Appeal Decision

Appeal Ref: APP/R5510/W/21/3276477

69 High Street, Ruislip HA4 8JB

- The appeal is made under section 78 of the Town and Country Planning Act 1990 against a refusal to grant planning permission.
- The appeal is made by Richard Hennessy (Blubuild.com Limited) against the decision of the Council of the London Borough of Hillingdon.
- The application Ref 1983/APP/2021/550, dated 10 February 2021, was refused by notice dated 15 April 2021.
- The development proposed is an extension at the front of the property above the shopfront to provide 1 x self-contained flat above (use class C3) at second floor level, and erection of a new three storey building at the rear of the property to provide 2 x self-contained flats (use class C3) above an open loading bay; with associated bin and cycle store.

First Floor Plan

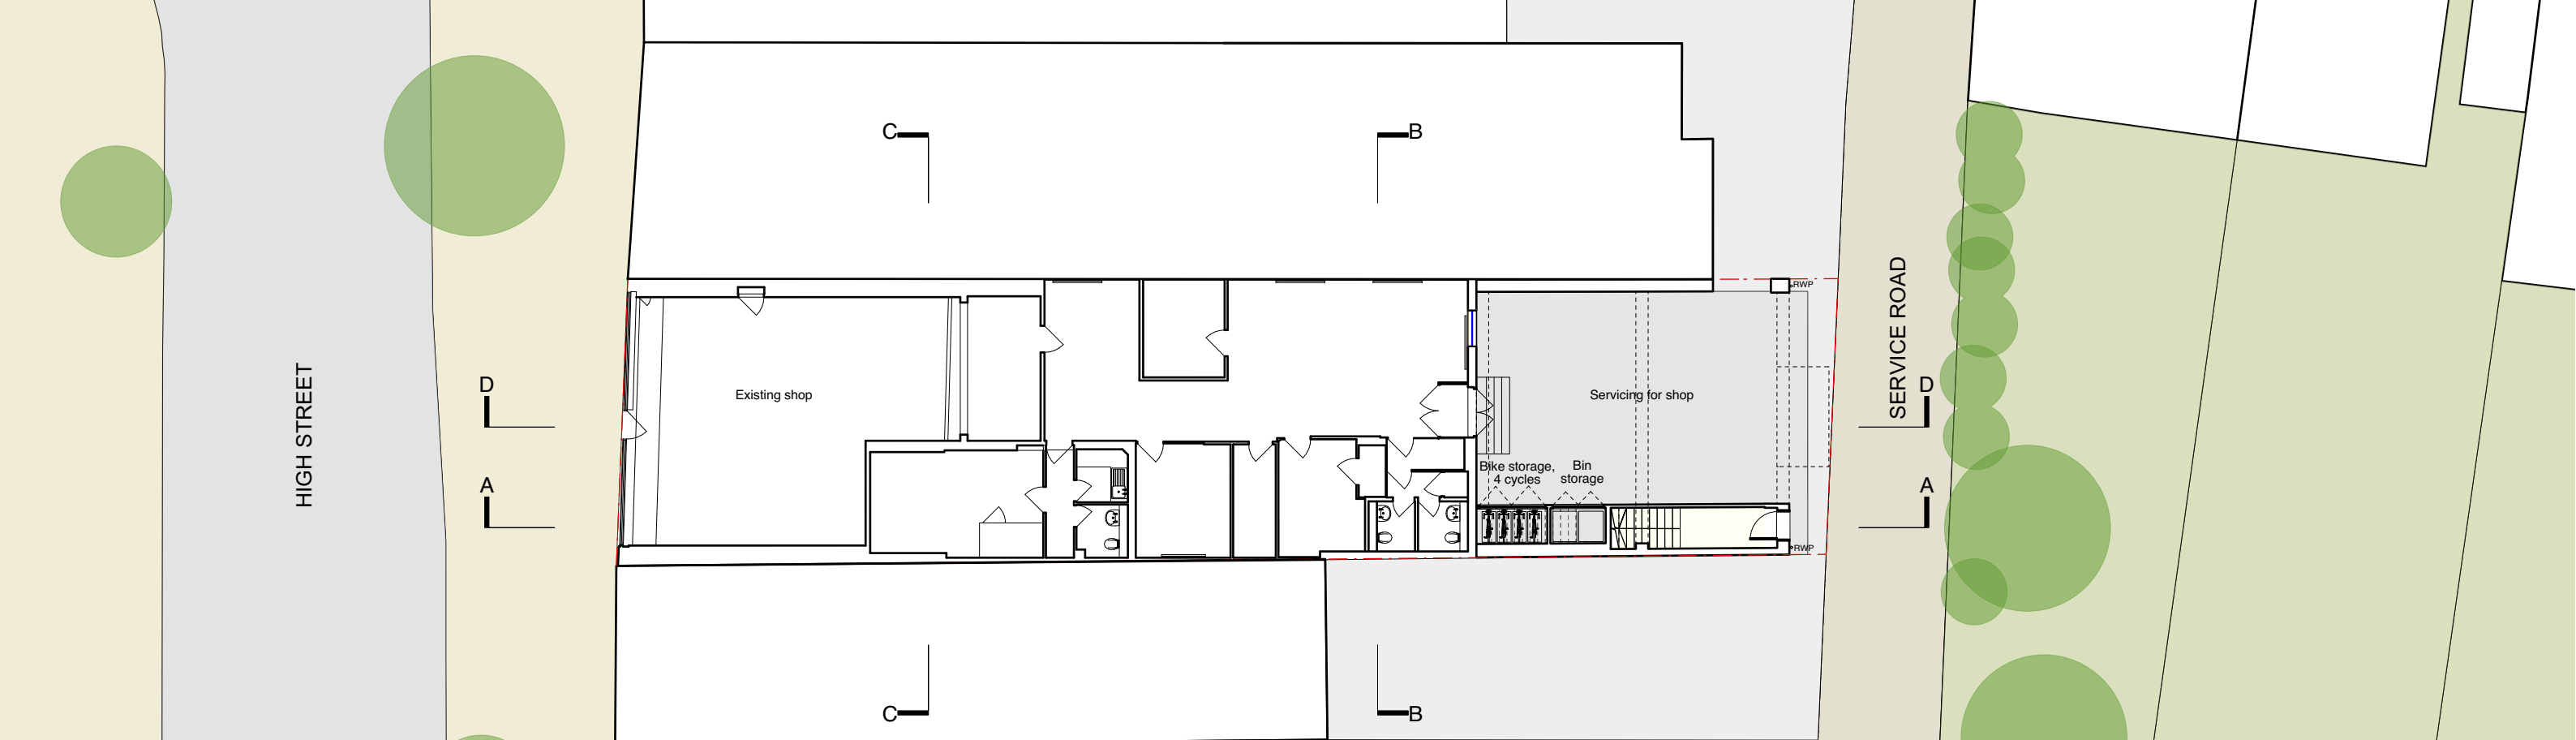
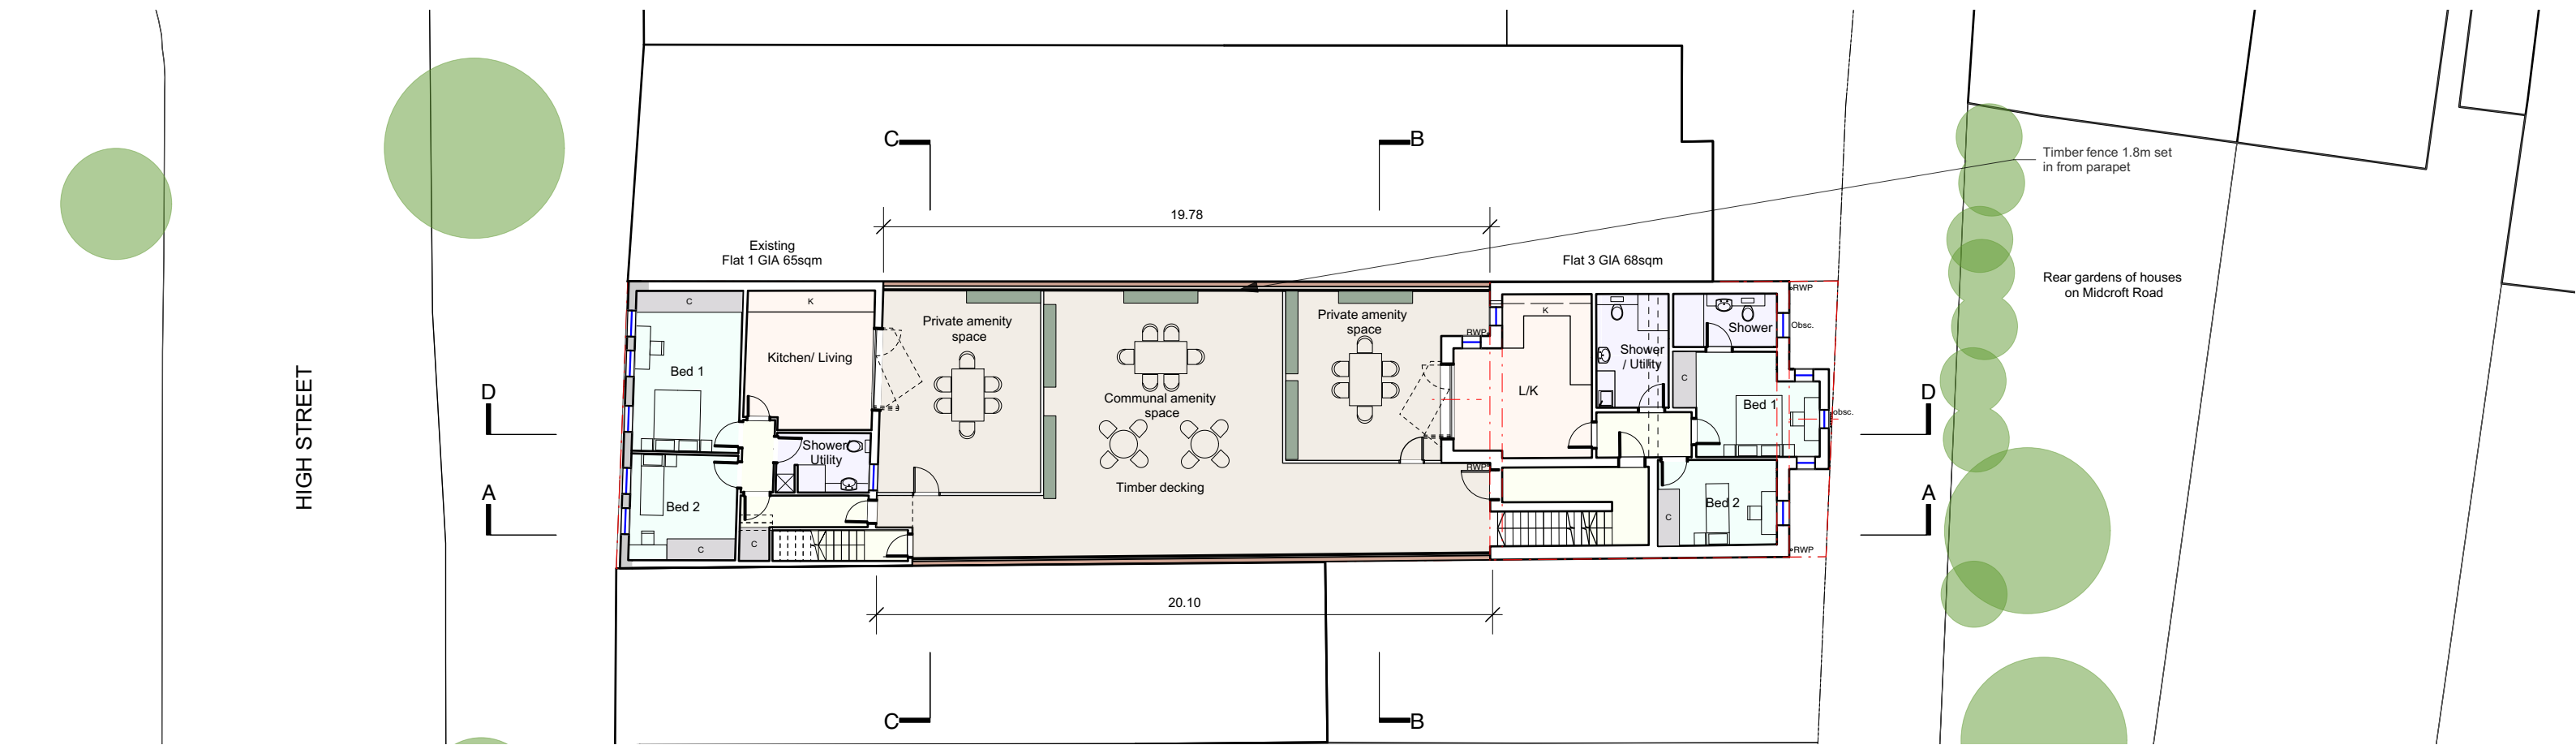
19. The windows of first floor units serving kitchen and living areas would face into enclosed private amenity spaces which would be separate from the communal area positioned centrally between the two elements of the proposal. While there would be some benefit to this private space, the amenity areas would be enclosed by a 1.8m fence. I therefore share the concerns of the Council that the proximity and height of this boundary would create a sense of enclosure resulting in a restricted and uninviting outlook for future occupiers. This would provide less than satisfactory living conditions for any future occupiers.

20. To conclude, while the proposal would provide satisfactory levels of daylight, it would not provide future occupiers with a suitable outlook, thereby not providing satisfactory living conditions in this regard. The proposal would therefore be contrary to Policies DMHB11 of the DMP and D6 of the LP which seek to ensure, among other things, that private amenity space should be usable and have a balance of openness and protection, appropriate for its outlook.

Section BB
Internal South West Elevation of Rear Building

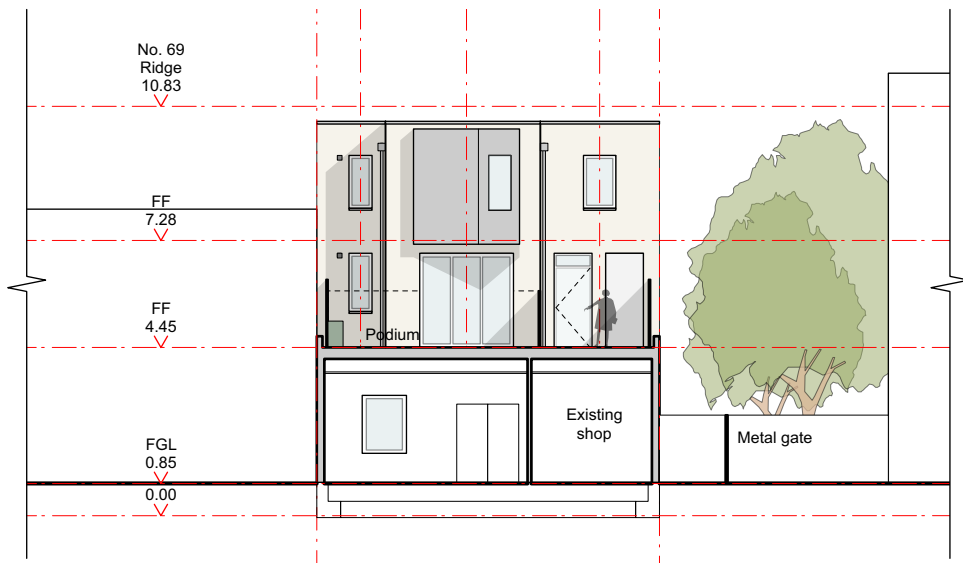
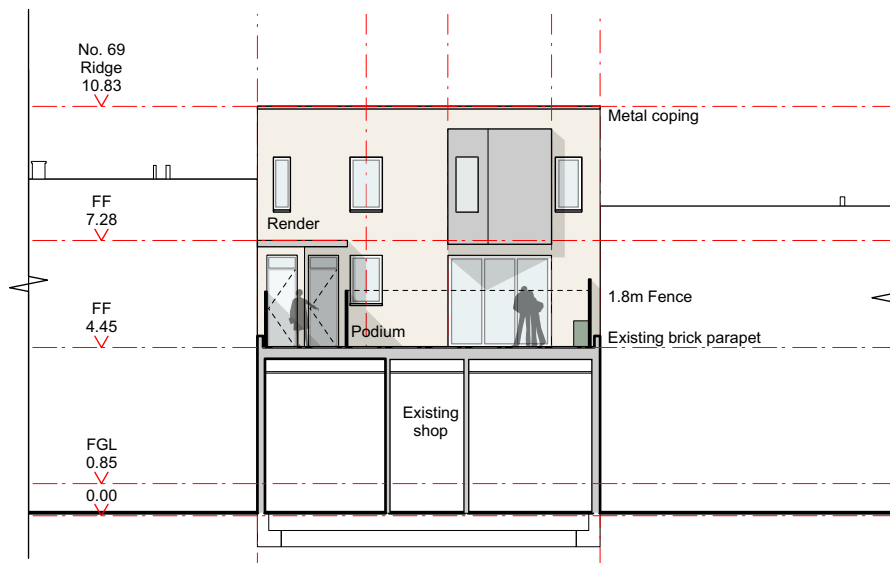
10. The proposed rear elevation of the extension would be largely hidden from most vantage points along Midcroft and from within the RVCA, especially given the enclosed nature of the amenity space the development would create. While I note the concerns of the Council regarding the use of render on this façade, which would not reflect other rear elevations, render is prevalent on other prominent buildings in the RCCA, such as the bank on the corner of Midcroft and High Street. Moreover, while there would be little architectural interest in the rear elevation of the extension, its general design would not detract from the character of the service lane.
